Subject: Next steps: Easement - to tie into City of Abq storm sewer - URGENT

Re: Folium Energy Solar Project, Annexation Portion Section 33

Grading and Drainage Plan

Engineer's Stamp Date 06-18-12 (M-21/D007E)

GRADING PLAN

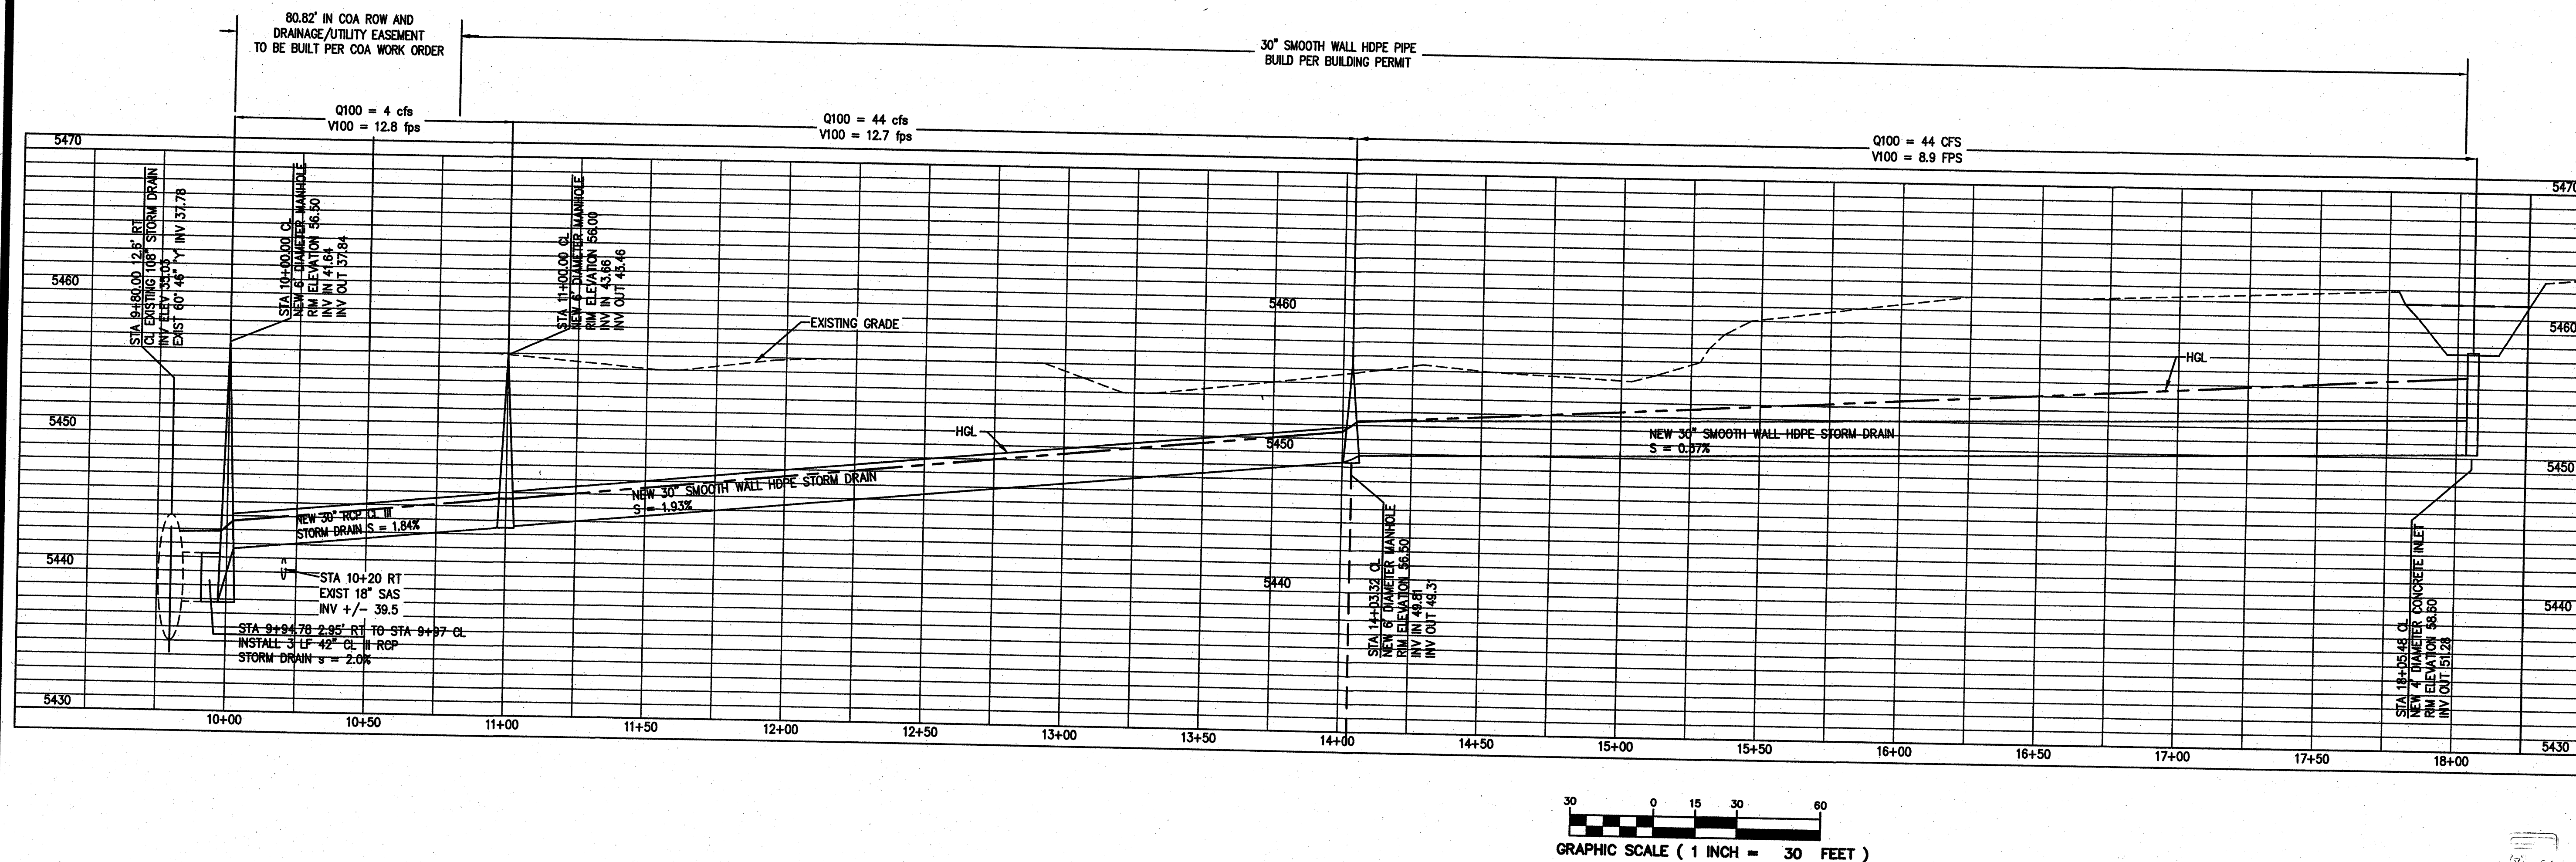
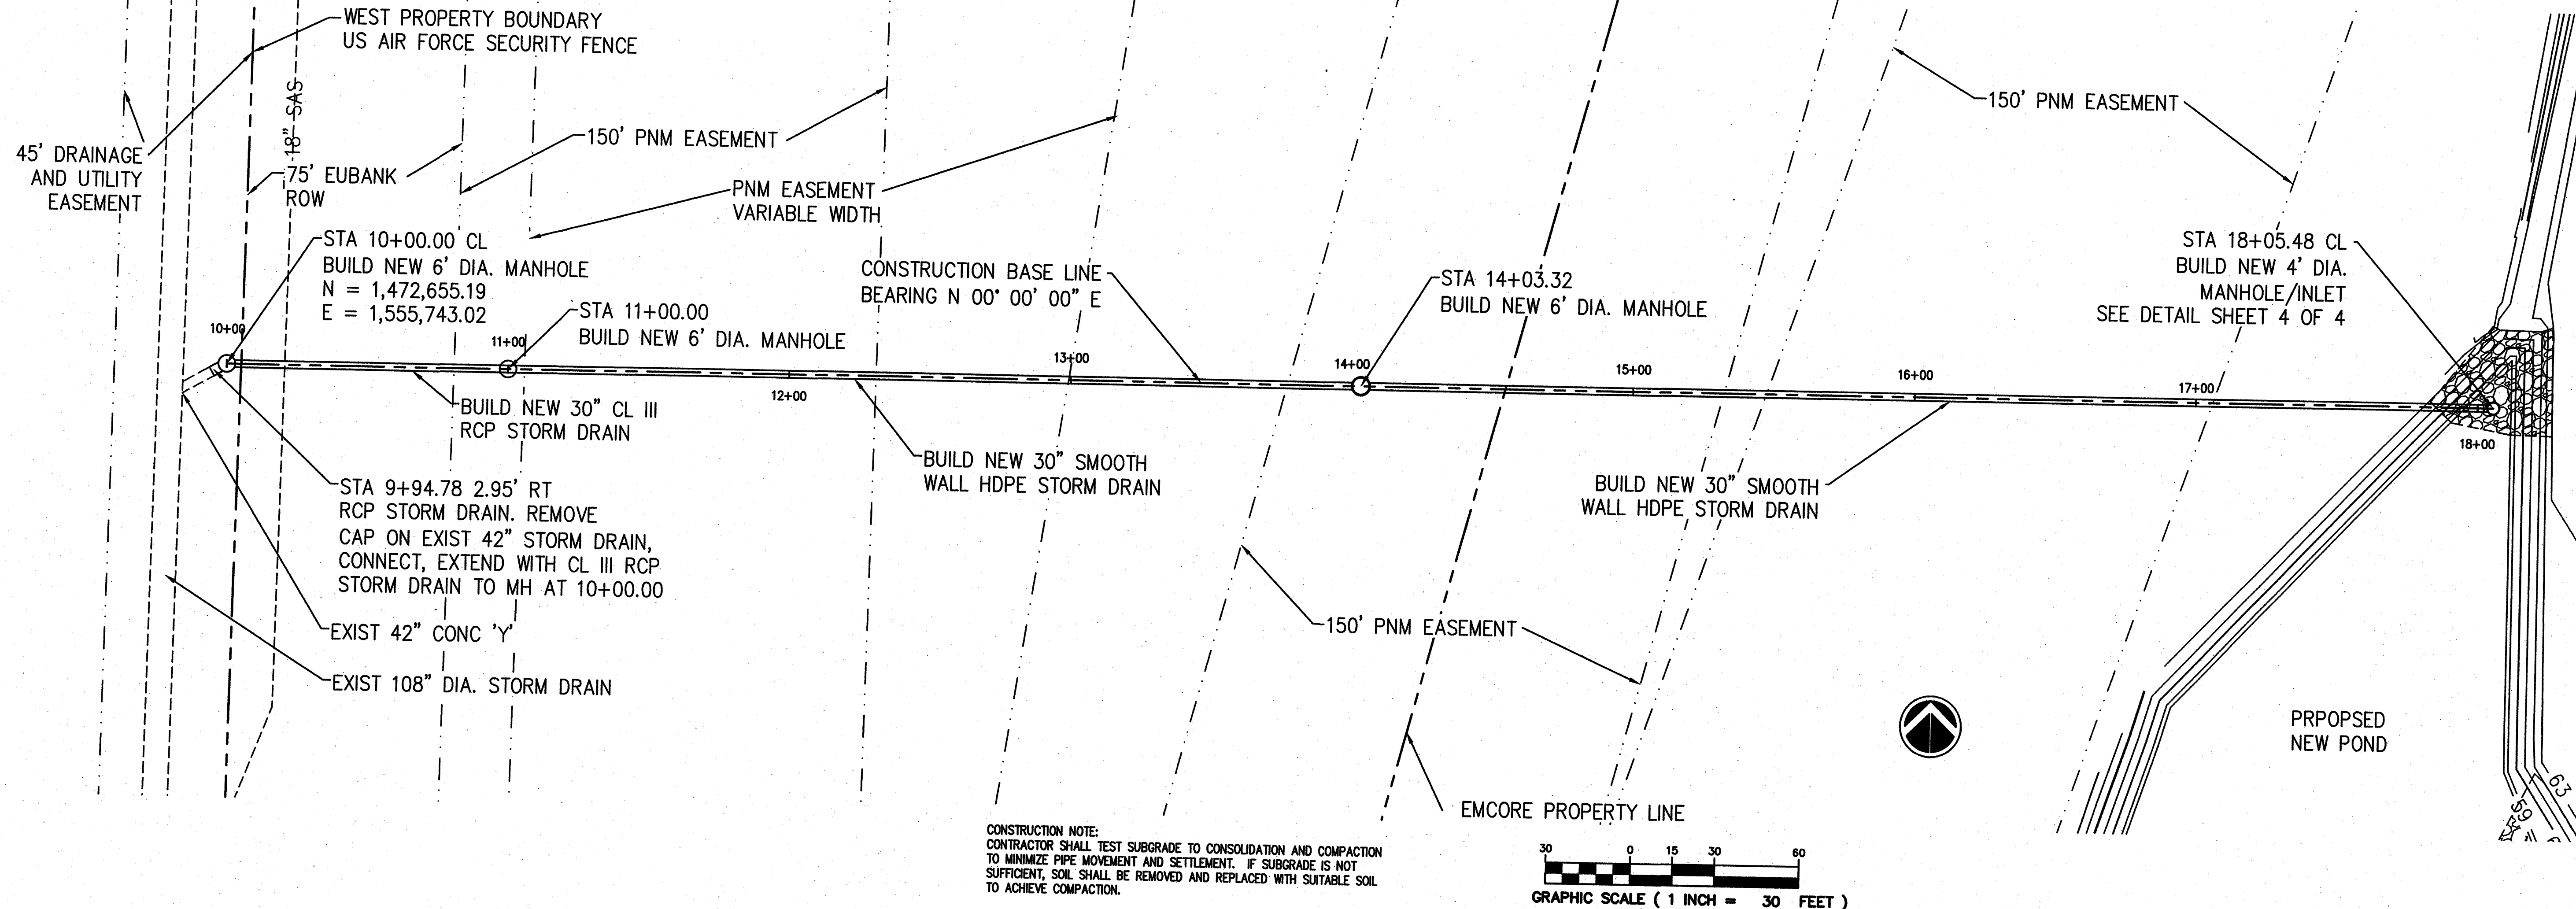
The plan concentrates the run off to the southwest edge of the development. The property south of the development is also part of the former landfill. This basically causes the outfall area to have twice the runoff that it would have had without the development. The waste has decomposed causing uneven settlement and ponding areas throughout the landfill. The added runoff can cause additional landfill gas generation in the property. Since the main constituent is methane, EHD is concerned that the requirements of the *Guidance for Compliance with the City of Albuquerque Environmental Health Department Interim guidelines for Development within City Designated Buffer Zones* cannot be met with the current design.

- The runoff discharge from the detention pond appears to be controlled by the 30" RCP.
- No weir calculation will be needed.
- Pond AHYMO Routing calculation is started at 58.50, but the top of the discharge point is at 59.00. The runoff is retained from 58.50 to 59.00.
- Environmental Health approval is required. Would the detention pond require a liner? Would a trench detail and ventilation be required?
- Since the storm drain pipe will be extended beyond the property line will there be a need for additional easements and encroachment agreements? Please clearly identify the existing property lines and easements on the plans.
- An encroachment agreement with PNM will be required.
- Provide an emergency overflow.
- The paving section should be 8" instead of 8' subgrade.
- The storm drain manhole within City of Albuquerque easement/right-of-way has to be submitted to DRC for approval.

- The developed flows in Basin B should not consist of 100% Treatment B since this entire basin will be graded. The asphalt lined channels should be considered Treatment D with the other surface areas Treatment C.
- Off site flows appear to enter Basin B from the north/northeast boundary. Is there a berm located along the northern property line?
- The pond elevation and calculations will need to be updated due to the increased flows once the treatment types are corrected.
- Section "B-B" is listed on the grading plan but does not appear on Sheet 3.
- On Sheet 3 the Asphalt Channel Lining Section denotes a scarification and compaction of the sub-grade to a depth of "8 feet". Is this intended or should it read "8 inches"?
- Will the site contain an access road? If so this should be labeled on the grading plan.
- The North Arrow on the plan is incorrect.

NEW STORM DRAIN PLAN AND PROFILE

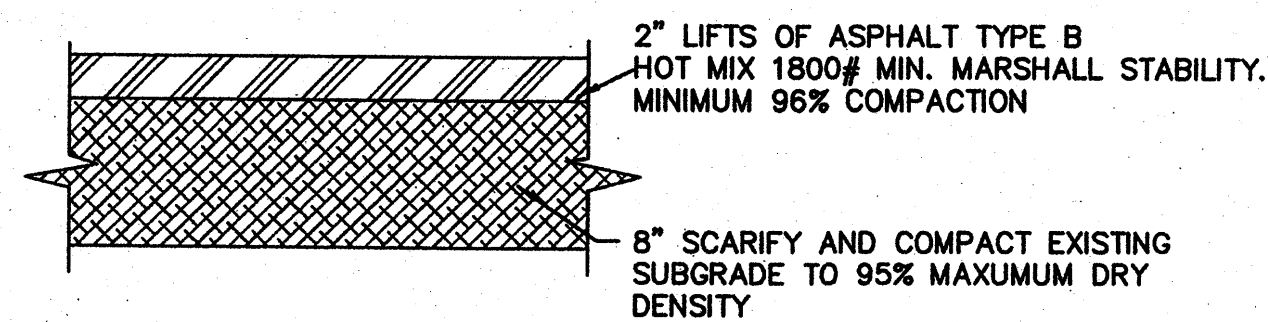
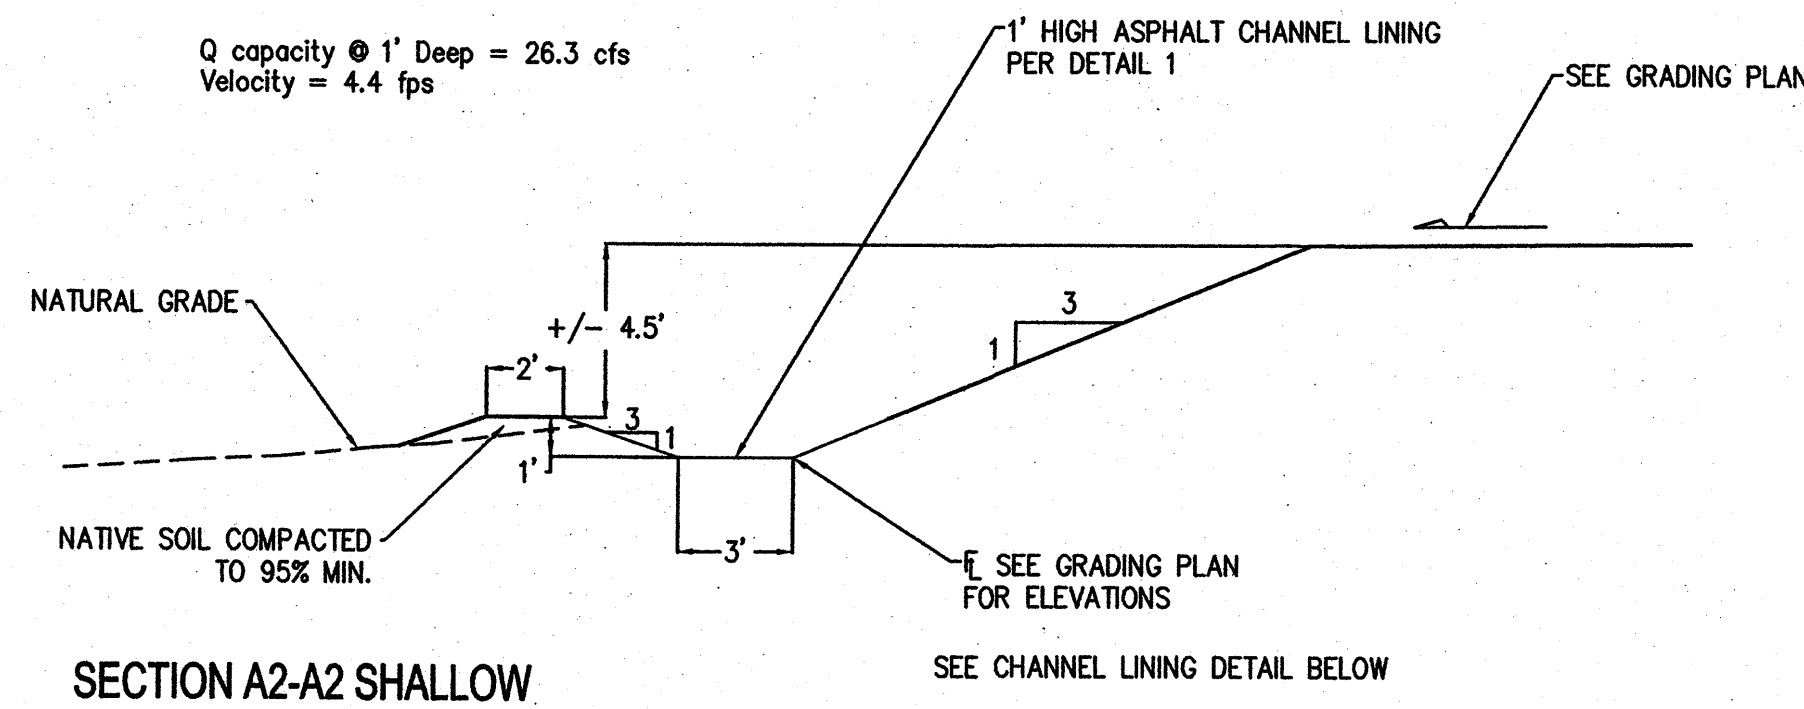
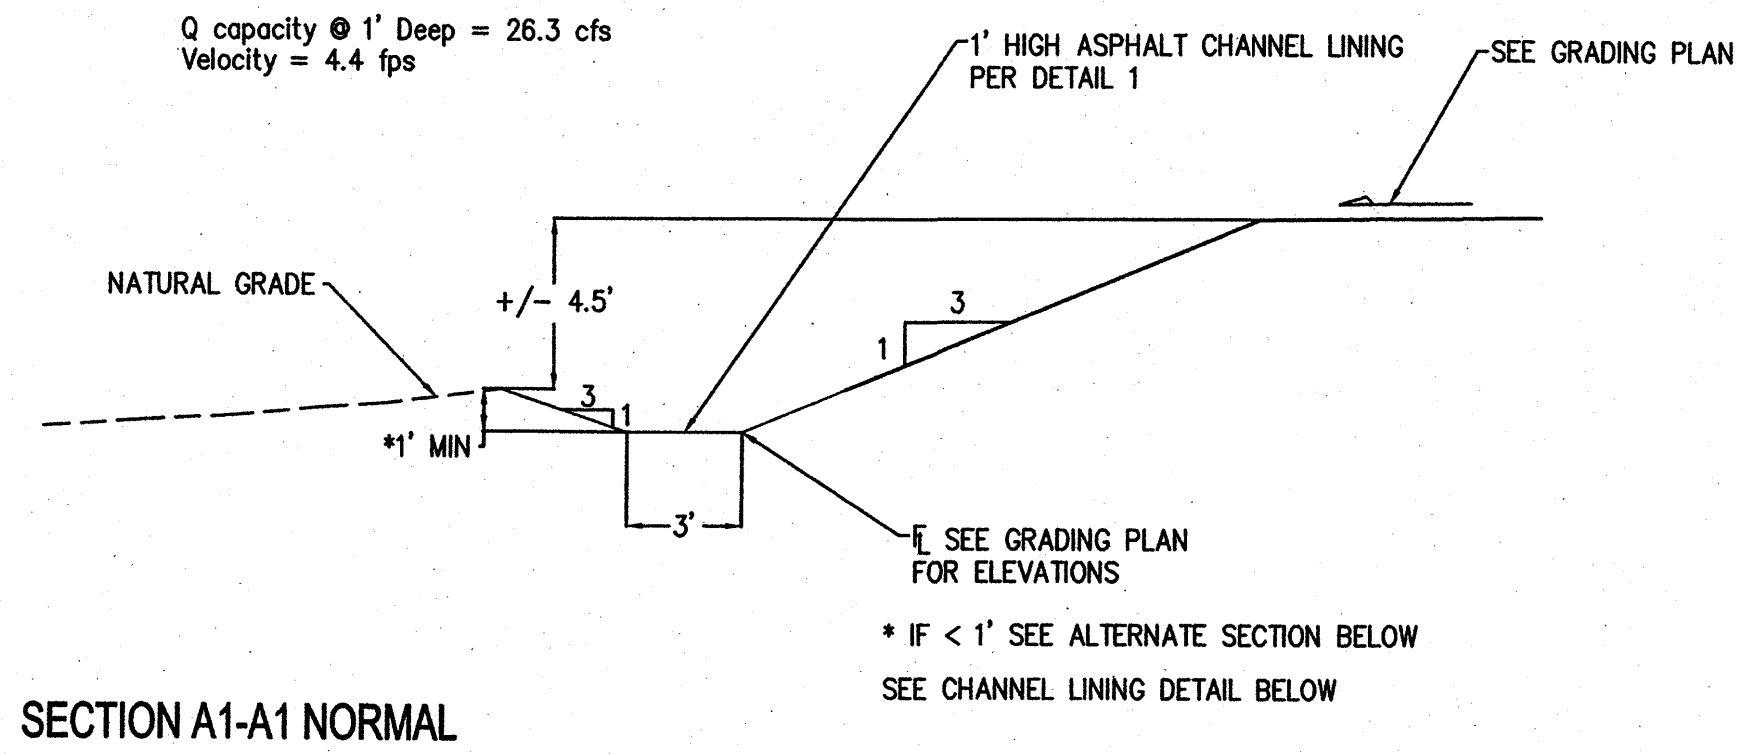
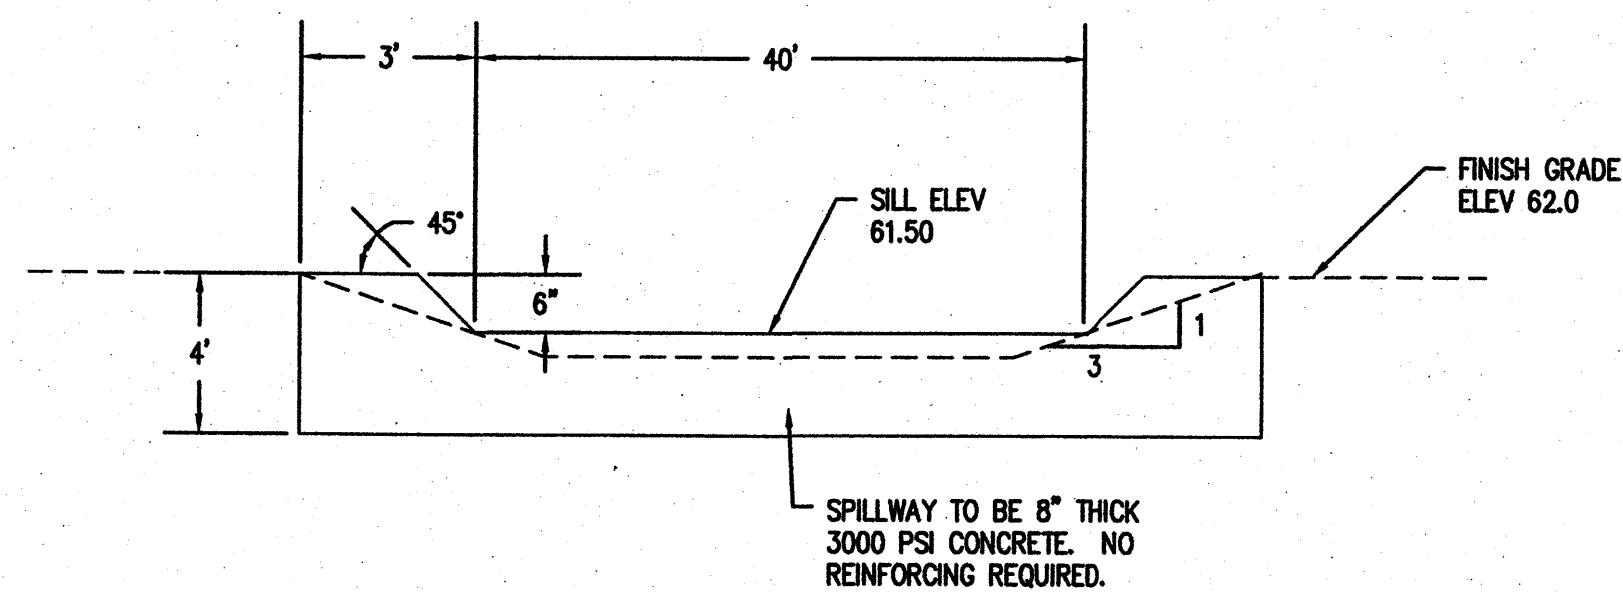
I have attached Hydrology's approval letter of the grading and drainage plan. Sheet 3 of 4 shows the connection to the storm drain on KAFB.

We will need KAFB approval to approve the construction plans (Work Order) that connect to the storm drain on KAFB.

The only hiccup I am seeing is that the facility gets built and we don't have a hook-up to the storm drain. Why hasn't progress been made with the KAFB folks in the past 8 months?

Hi Randy, there is no reason to hold up the building permit on this item. However, prior to the certificate of occupancy being issued, the storm drain must be completed. Suzanne
